HPG RESPONSE TO TARONGA ZOO SKY SAFARI ENVIRONMENTAL IMPACT STATEMENT SSD-46807958

Submission Taronga Zoo Sky Safari Environmental Impact Statement SSD-46807958

Figure 4 Lower station ground floor plan

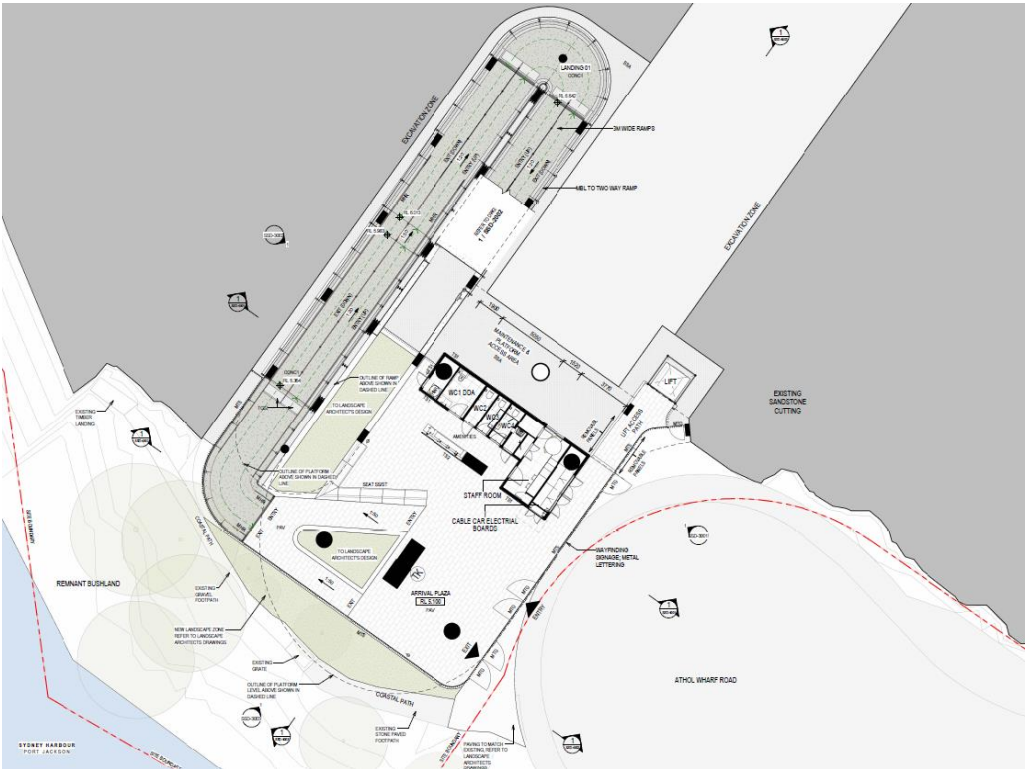
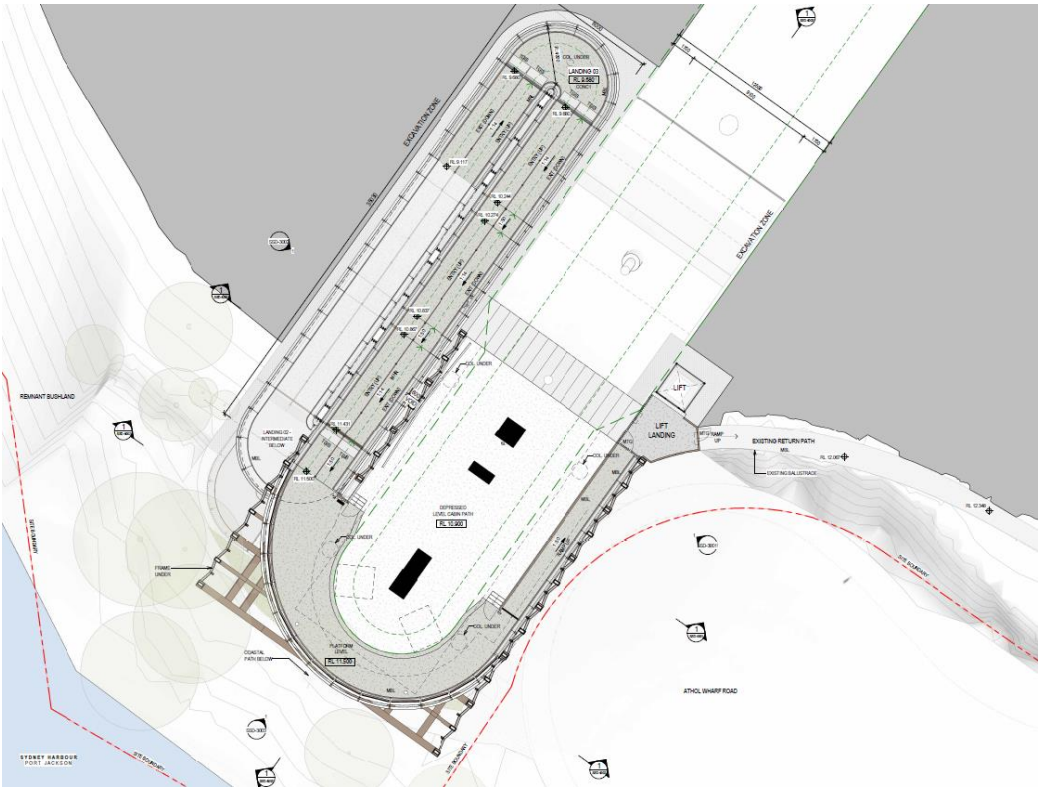
The proposed Lower Station (Viewpoints 18,19,20,22,23) will result in a change to the Zoo's visual setting from various locations around the harbour, making it more intrusive. It does not "blend in" with the natural environment. (EIS p87)

The proposed location of the planned new entrance to the lower station will remove the current intrusive 30 steps to the entrance of the cable car. An arrival plaza, the integration of core amenities, a lift and seating for guests is commendable. However, local endemic vegetation will be removed to allow this walkway in the proposed location.

It is hoped that the location of the ramp at the back of the station will be less noticeable from the Athol Wharf and Bradleys Head Road than the current steps. The opening of the bottom entrance of the Zoo to receive guests will hopefully help reduce waiting queues. However, we suspect that only a minority of visitors will choose to enter there as it involves walking up the relatively steep incline inside the Zoo rather than being driven to the top entrance. Entering the Zoo from the top entrance allows them to walk down the hill through the Zoo and this is far preferable to visitors than the alternative.
